Your Ref: Norwich-Tilbury Drainage Strategy Ref: FW2026_0440
Date: 09 June 2026 Tel No.: 0344 800 8020
Email: llfa@norfolk.gov.uk

Norwich to Tilbury: LLFA Review of Drainage Strategy

Thank you for your consultation on the above site, received on 28 May 2026. The LLFA have reviewed the submitted information and have the following comments to make.

THE NATIONAL GRID (NORWICH TO TILBURY) ORDER
INDICATIVE OVERHEAD LINE PROFILE RG ROUTE
REGULATION 5(2)(o)
SECTION A, SHEET 2 OF 24
SOUTH NORFOLK COUNCIL

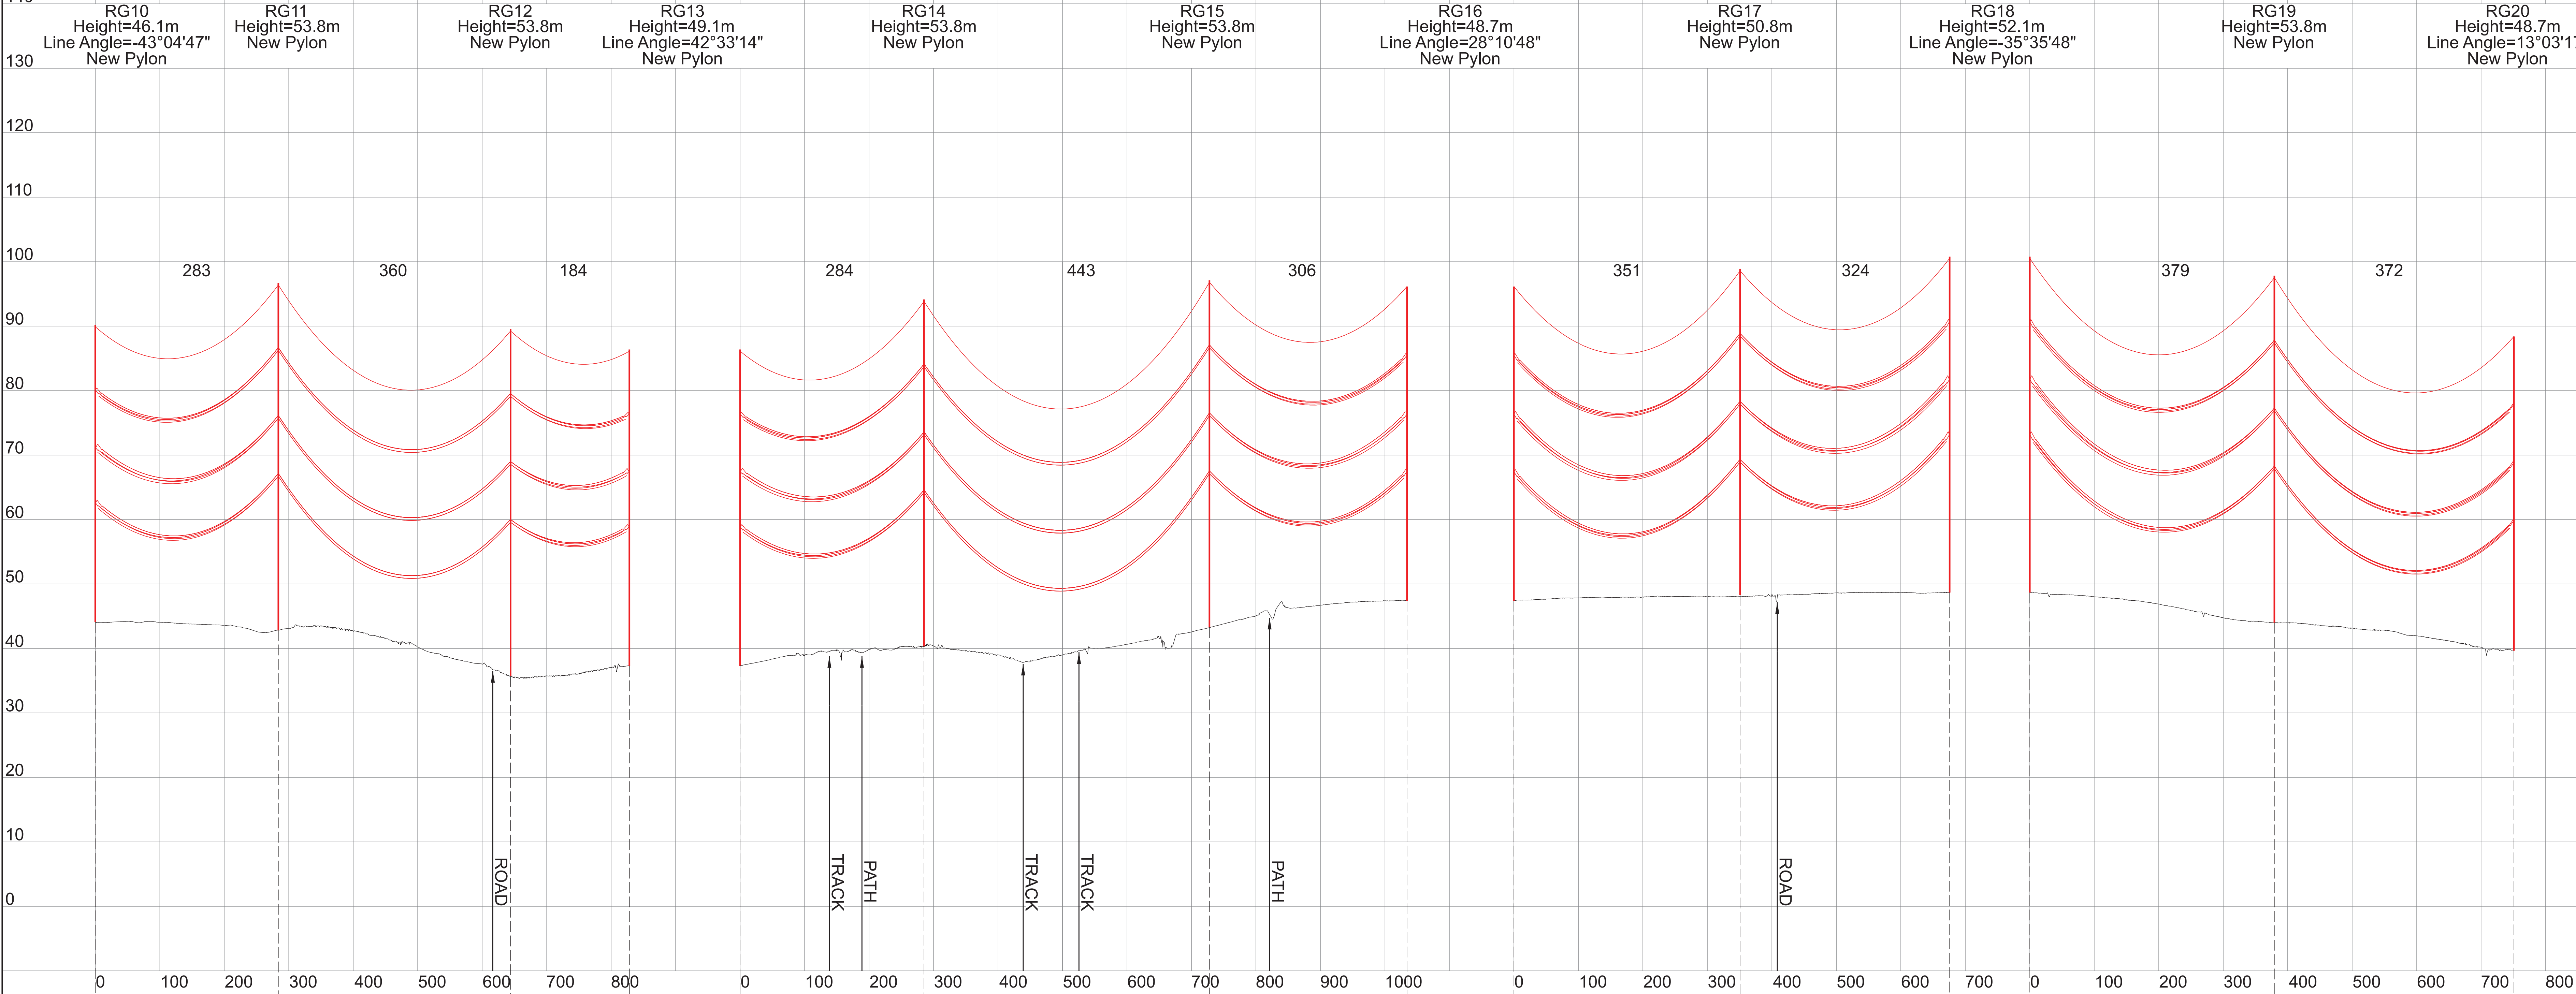
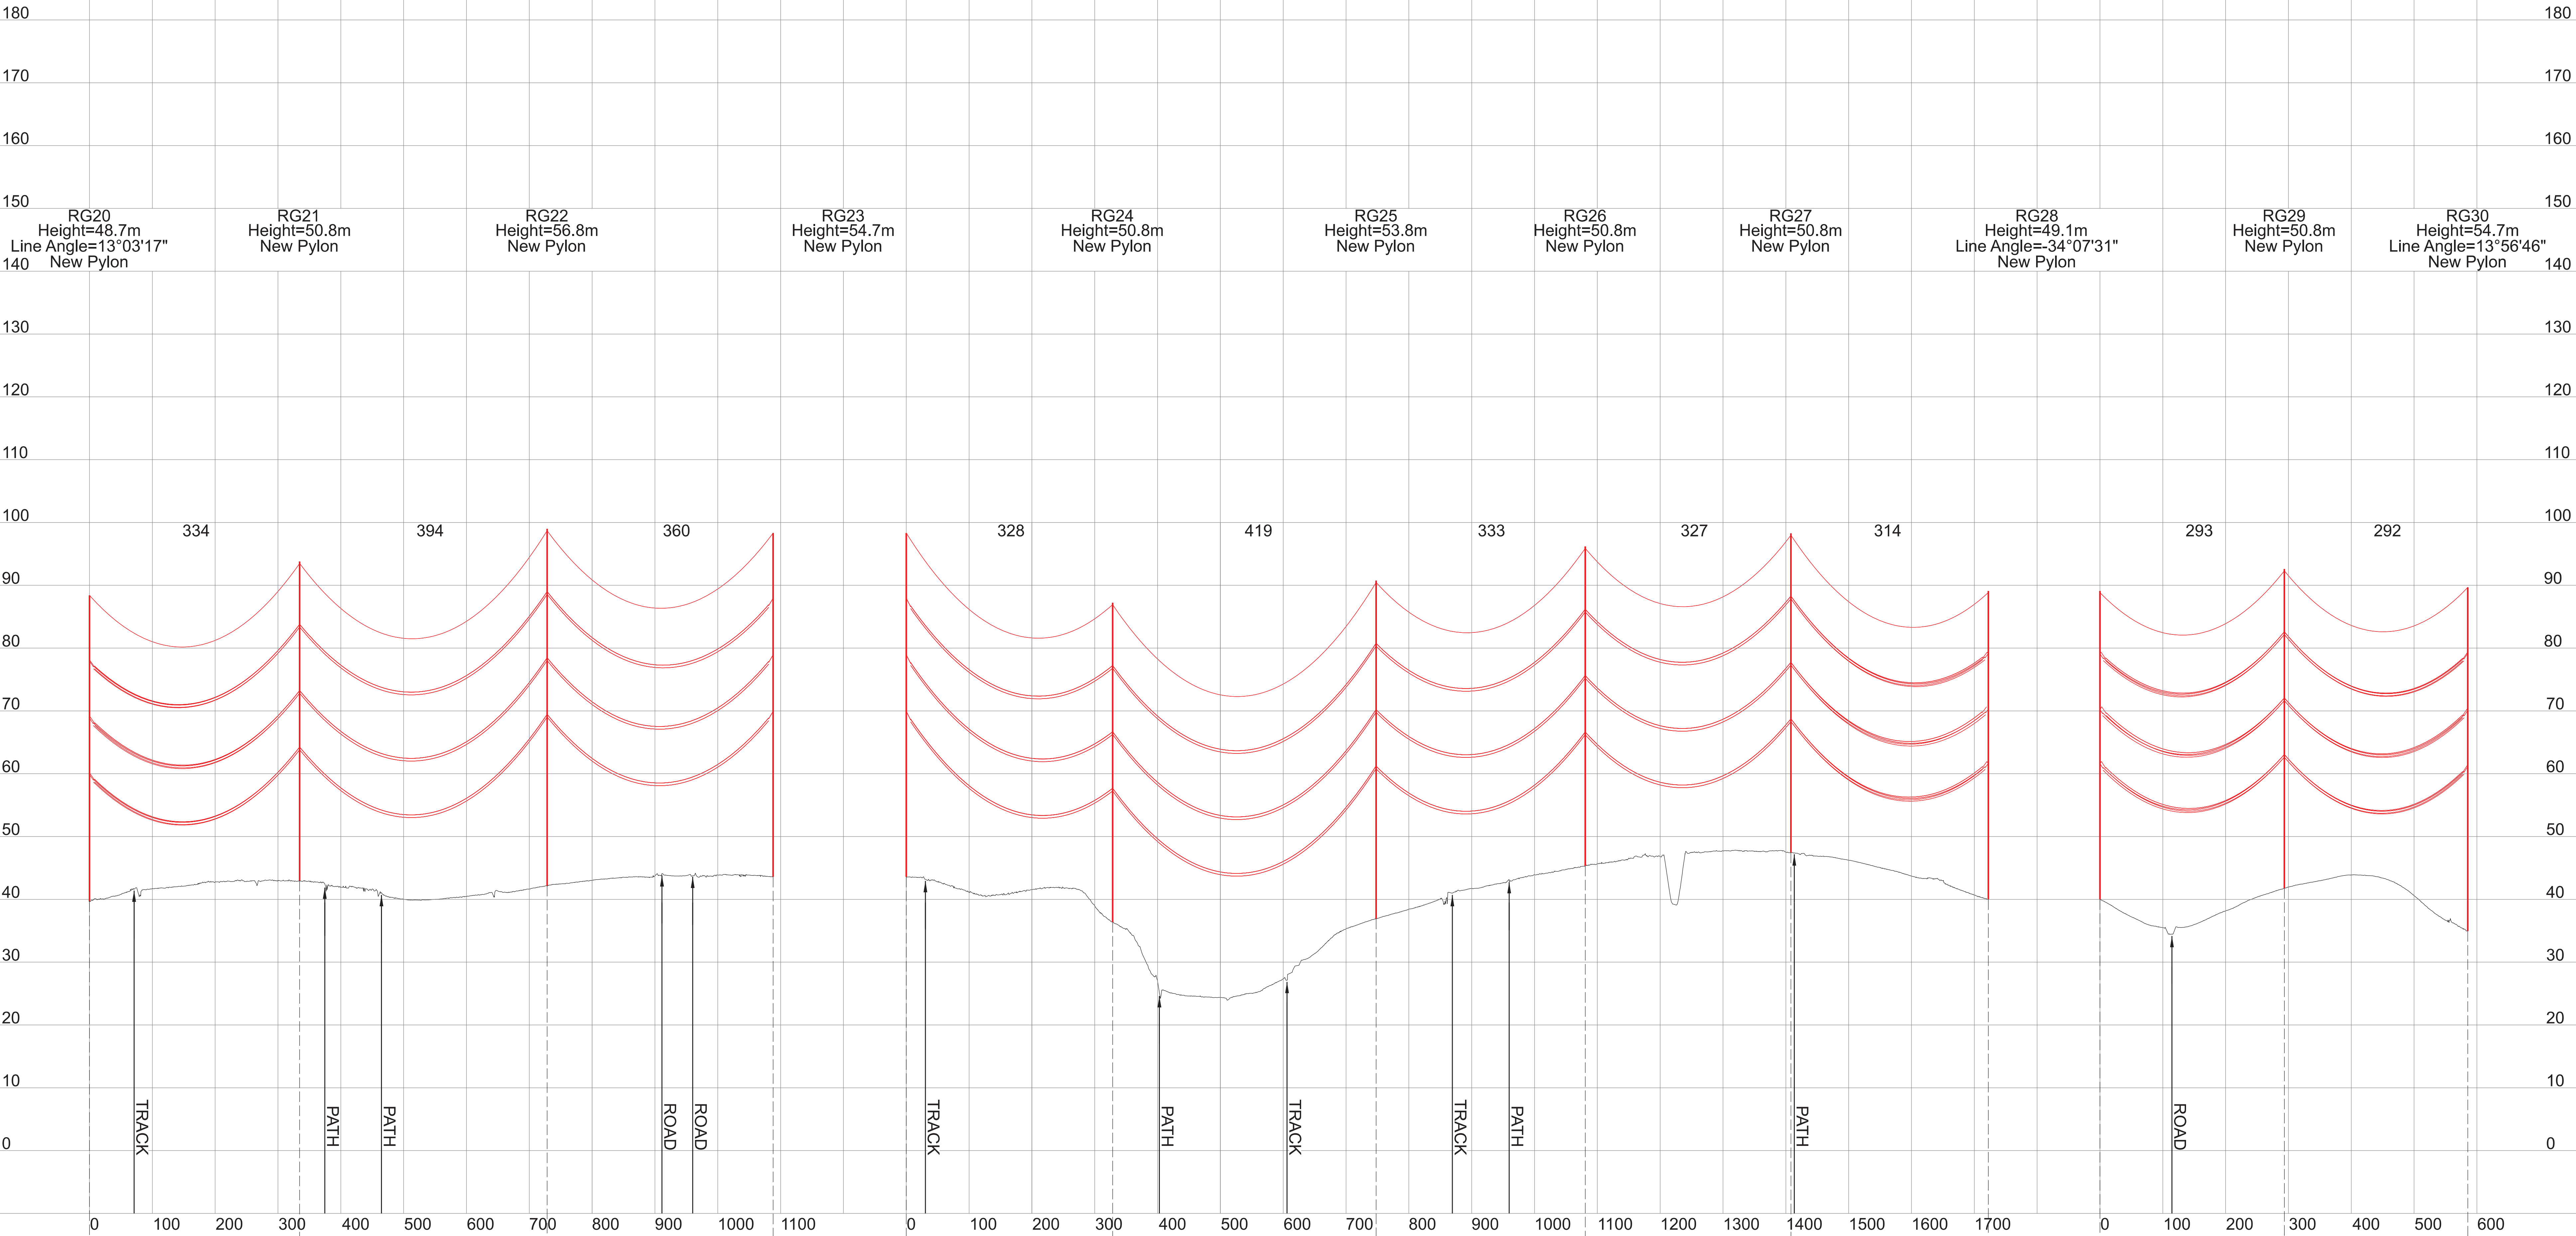
LLFA June 2026 Response - Partly Resolved - The applicant has removed the statement of "There are no steep slopes or rapid changes in elevation" and "however, slopes are still relatively shallow and rolling". There is now an inclusion of text that references 2.7 Elevation Drawings - Overhead Line Profiles - Part 1 of 2 [APP-044]. These drawings are not easy to interpret but they do give an indication of the topographic levels in relation to the proposed overhead lines. However, due to the scale and notes on the drawings, the levels appear to be indicative and focus only on the levels on the centerline below the overhead line route. The LLFA continues to request more suitable detailed information at this stage.
